Our Ref: BR/36/14/A

Town & Country Planning (Control of Advertisement) (England) Regulations 2007 (as amended)
Application for Advertisement Consent

Development Part illuminated fascia sign and projecting sign
Location 3 Phones 39 London Road Bognor Regis West Sussex

39 London Road

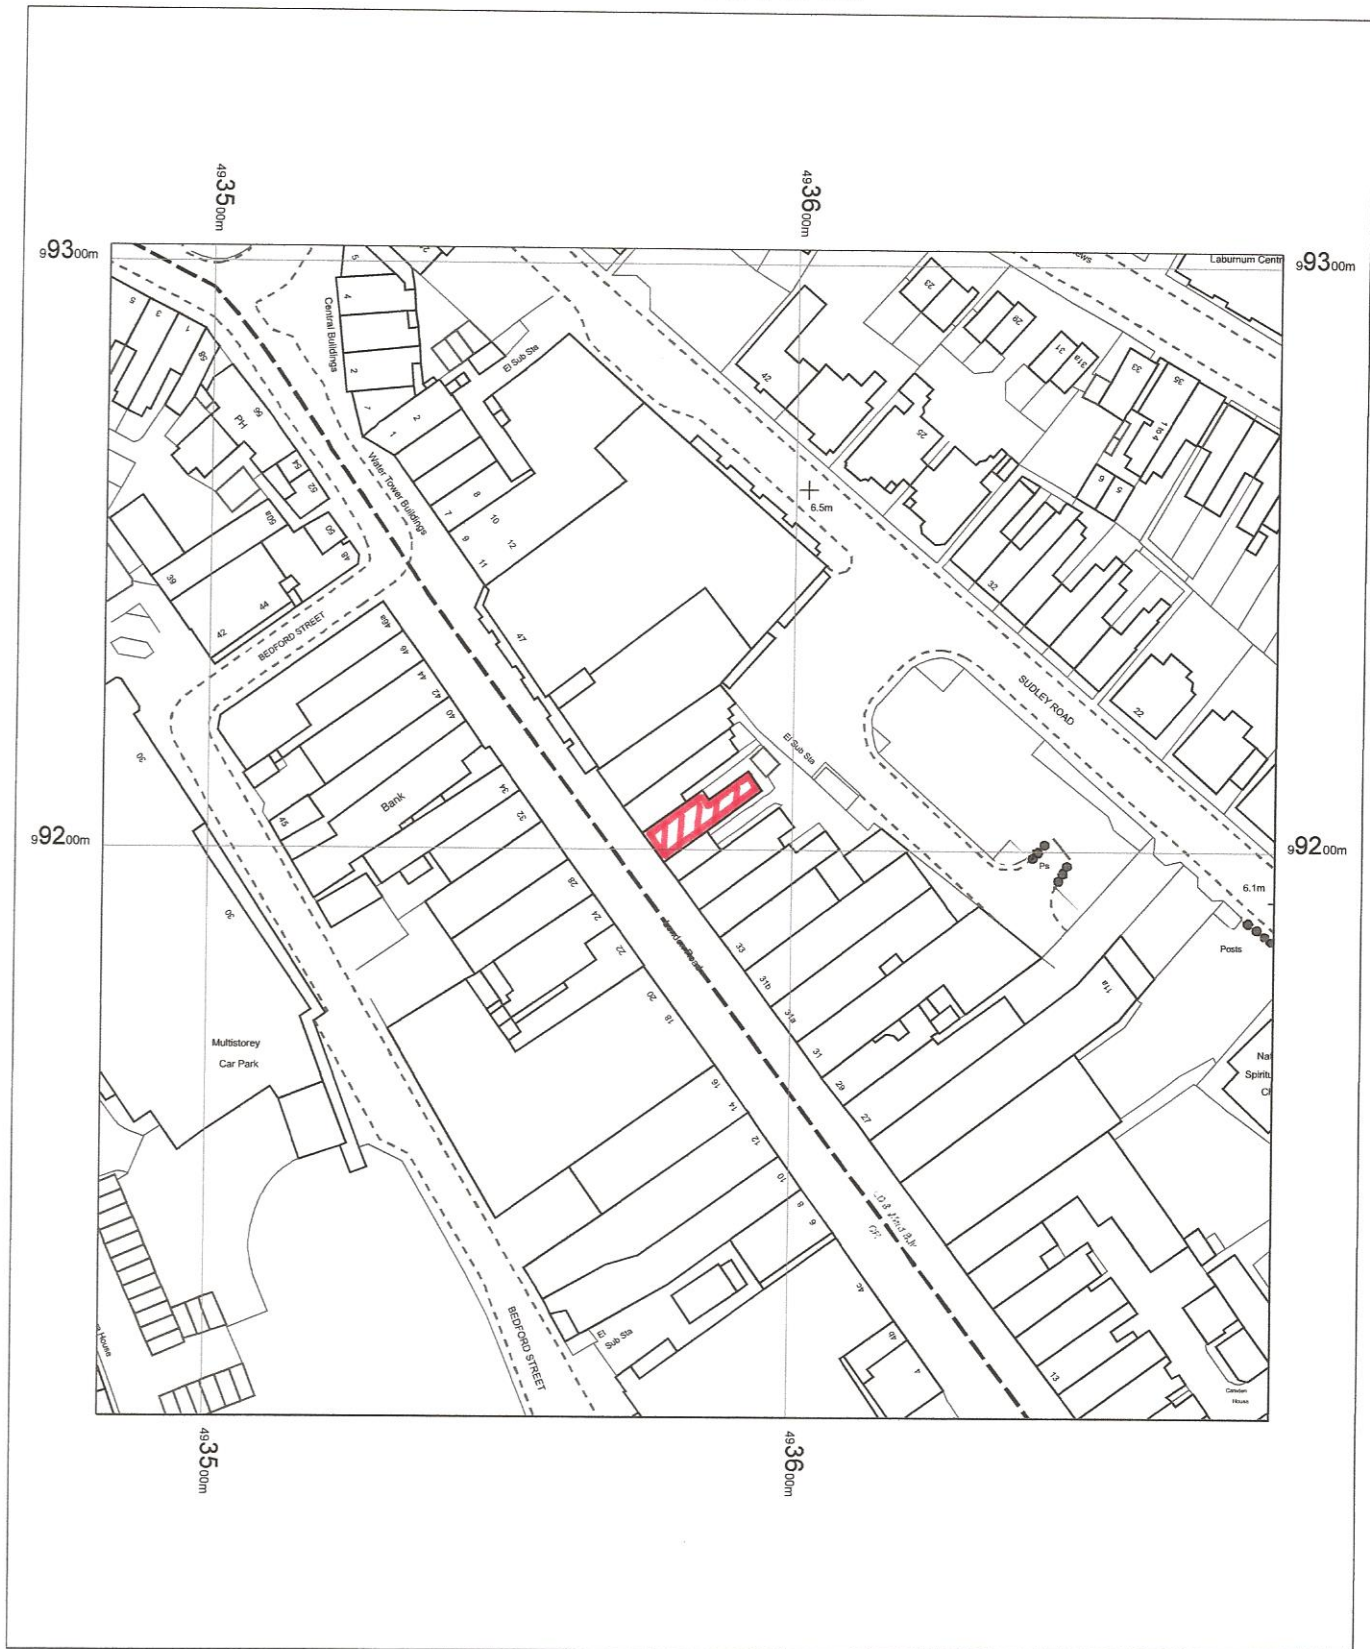
Block Plan

Please submit 1 electronic or 3 paper copies of an amended block/site plan showing the position of the proposed signage. I line in another colour together with an arrow indicating will suffice
